STATE OF NORTH CAROLINA
DEPARTMENT OF TRANSPORTATION

July 30, 2004

Subject: **Tar-Pamlico Buffer Certification Modification Application** for the Replacement of Bridge No. 72 over Hachers Run on SR 1004, Granville County. Federal Aid Project No. No. BRSTP-1004(7), State Project No. 8.2370901, NCDOT Division 5, TIP Project No. B-3643.

# PREFORMED SCOUR HOLE WITH LEVEL SPREADER APRON

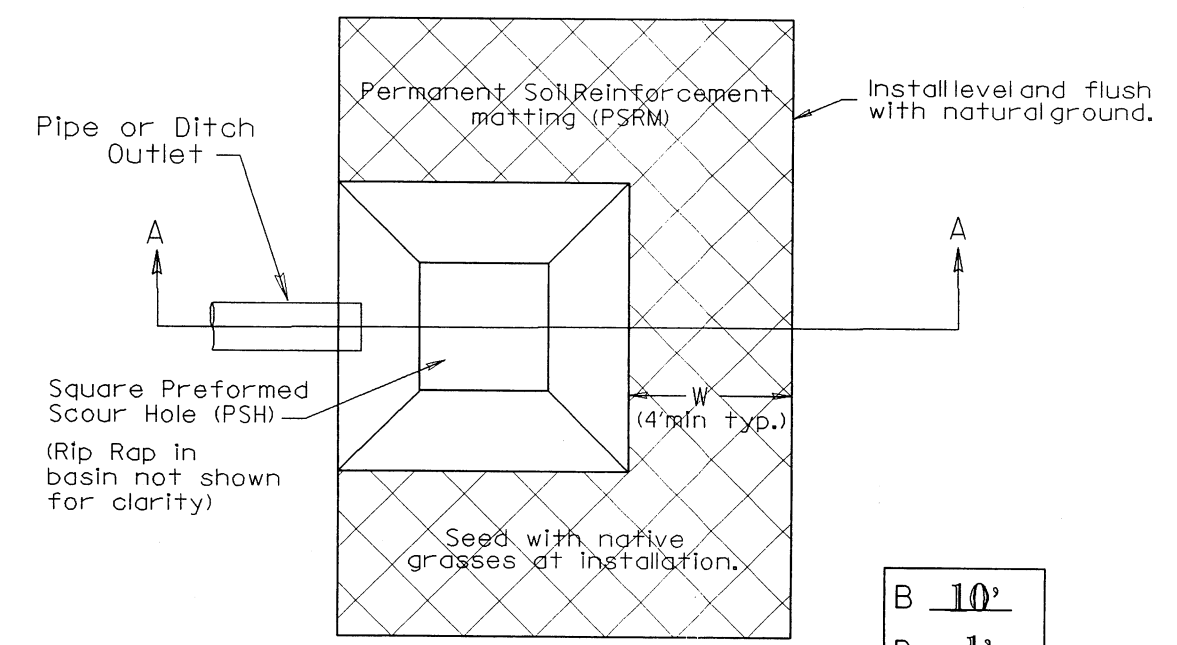
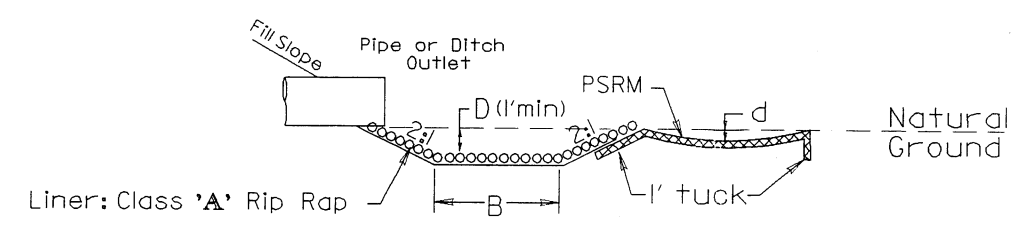
The changes outlined in this modification application do not compromise NCDOT's compliance with the existing permit conditions. The location of the Preformed Scour Holes (PSH) and the lateral ditches associated with these 3 PSHs in the northeast, northwest and southwest quadrants has changed. The PSHs and lateral ditches have been moved out of the wetlands. Impacts to the wetlands have not changed. Additional area will also be required to allow access of construction equipment. Impacts to Tar-Pamlico riparian buffers have increased in Zone 1 from 1,811ft² to 3,241ft² and Zone 2 from 1,367ft² to 2,072ft² to allow access of construction equipment.
